Fontwell Avenue,
Eastergate,
West Sussex.
PO203RU
14.02.18

We wish to object to planning application AL/136/17/PL for the reasons listed below:-

PROPOSED SITE PLAN 1:200

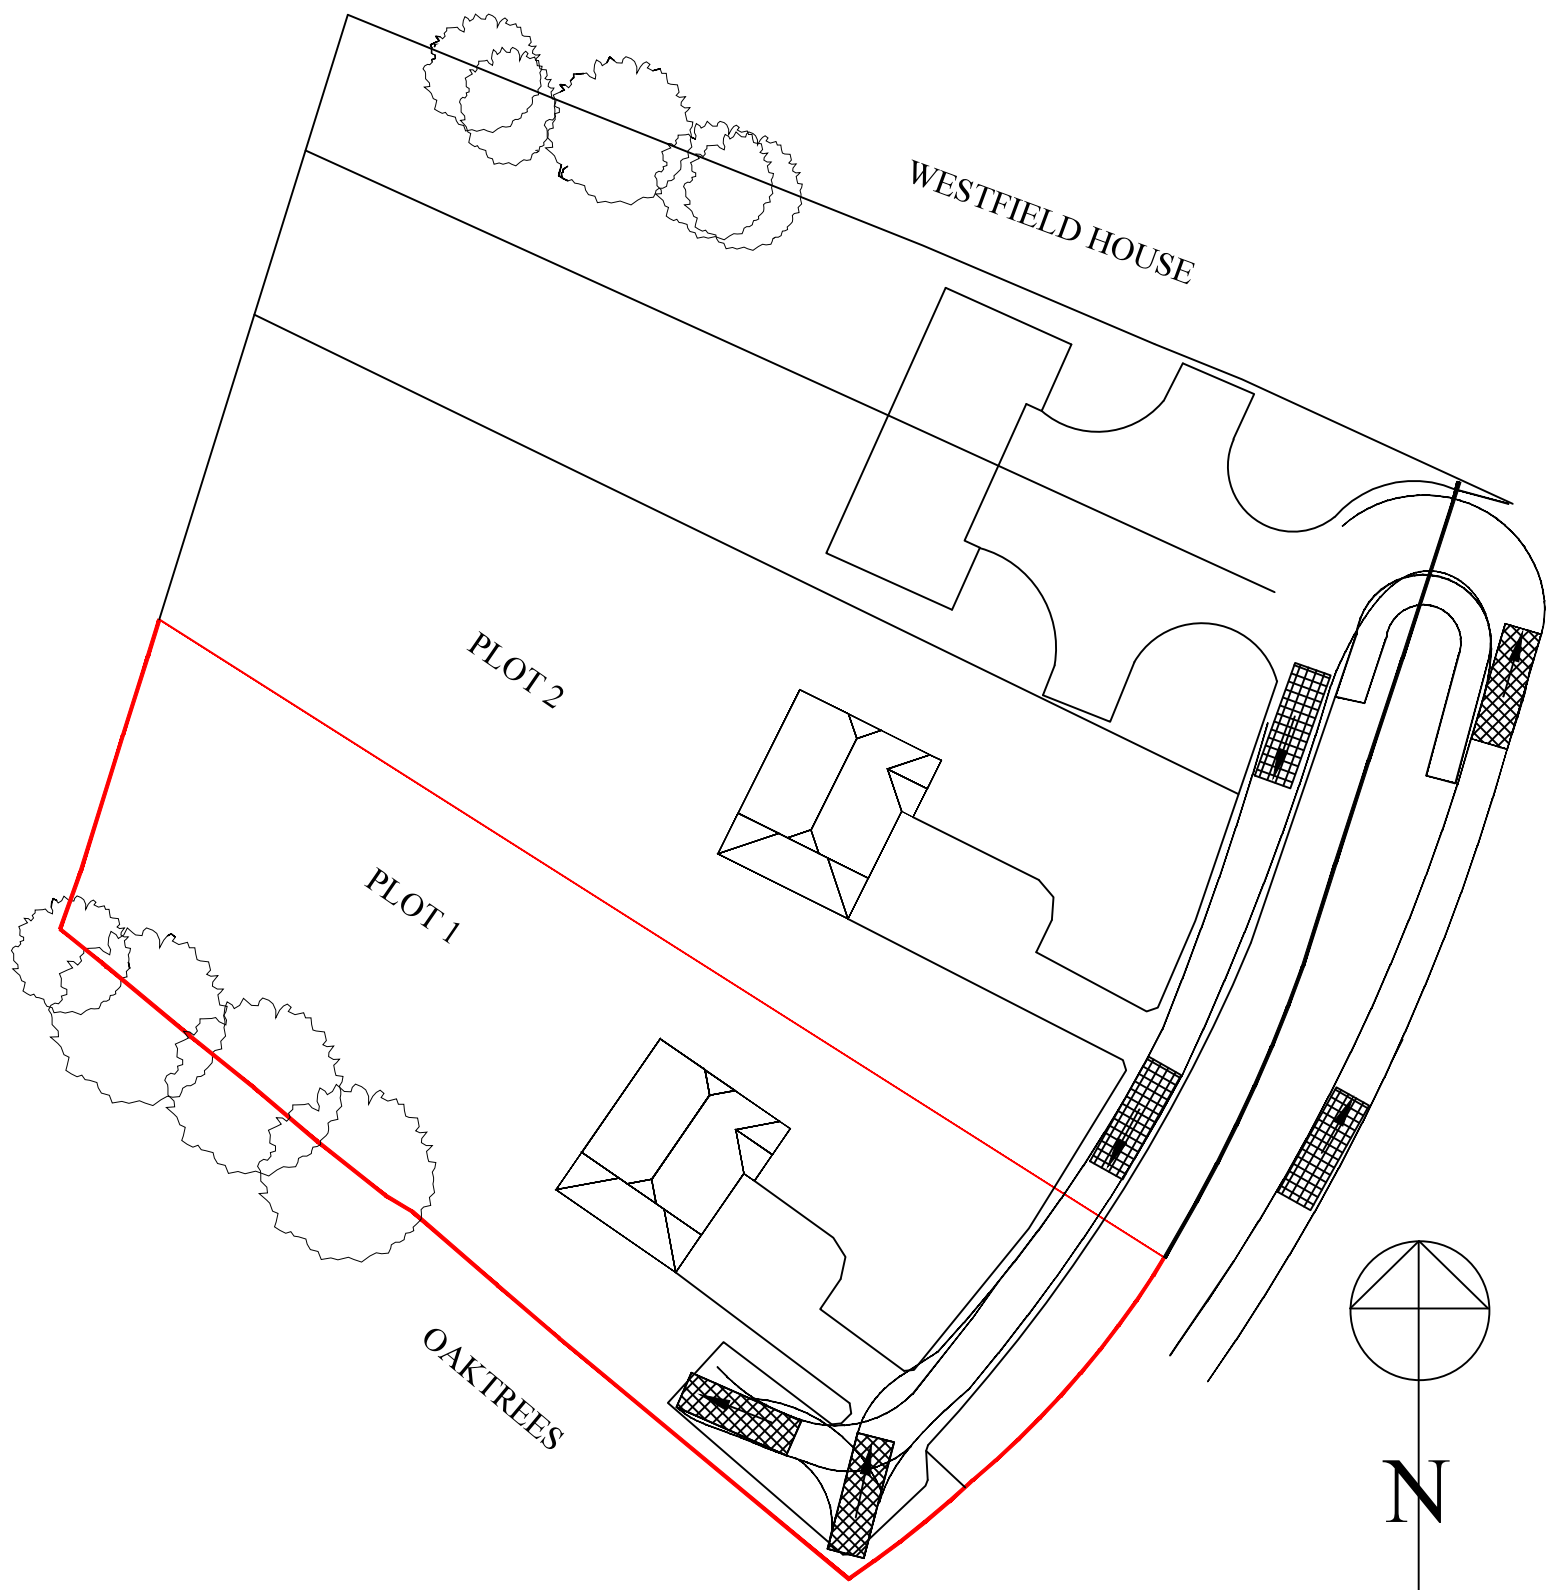
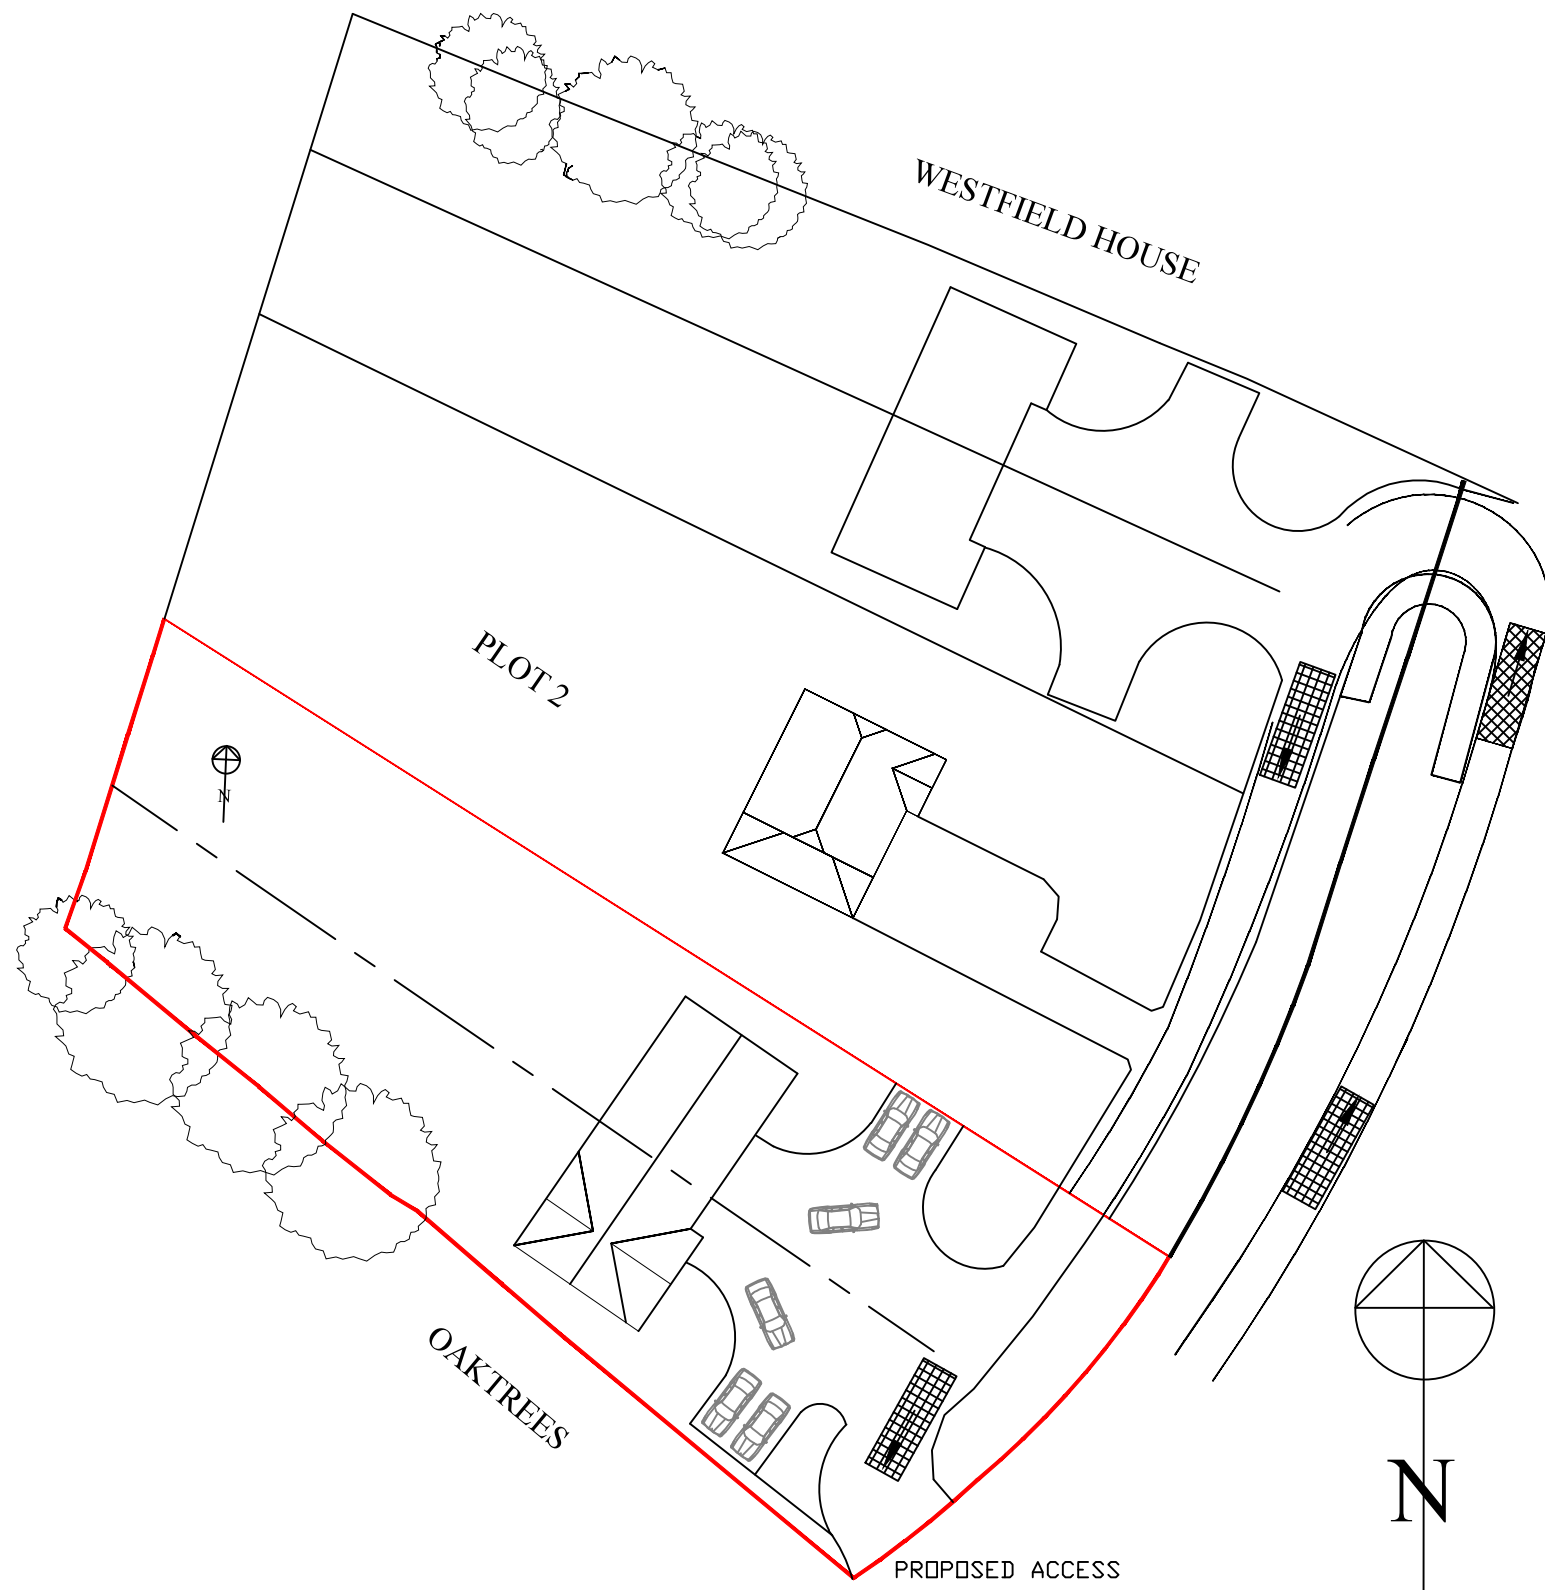
The units on this site are calculated to require three parking spaces. The six units (when this application is passed) will require eighteen cars to be parked at the front of the properties. – In essence – a car park! The units already agreed and those proposed, have no garages and no rear access. Therefore, any visiting cars will need to park in the access road. It will become a ghetto, which will restricted free access to ambulances, fire engines and the like, **especially if the road carries traffic moving and parking in both directions.**

This application has brought the number of properties to six, clearly negating the desk top study. This application provides a 'way round the problem', which of course the Council will have to agree to – another access at the other end of the field. - Another object lesson in **'How to hoodwink the Council'**.

Adding another access point will not ensure that cars entering and exiting the site, do so from the designated entrance. A second entrance would also mean the turning area previously agreed for the end of the access road would not be possible. Another blatant manipulation of the Planning System.

It is not positioned correctly according to the planning permission already given and is much wider than the one shown on the plan. They have in fact
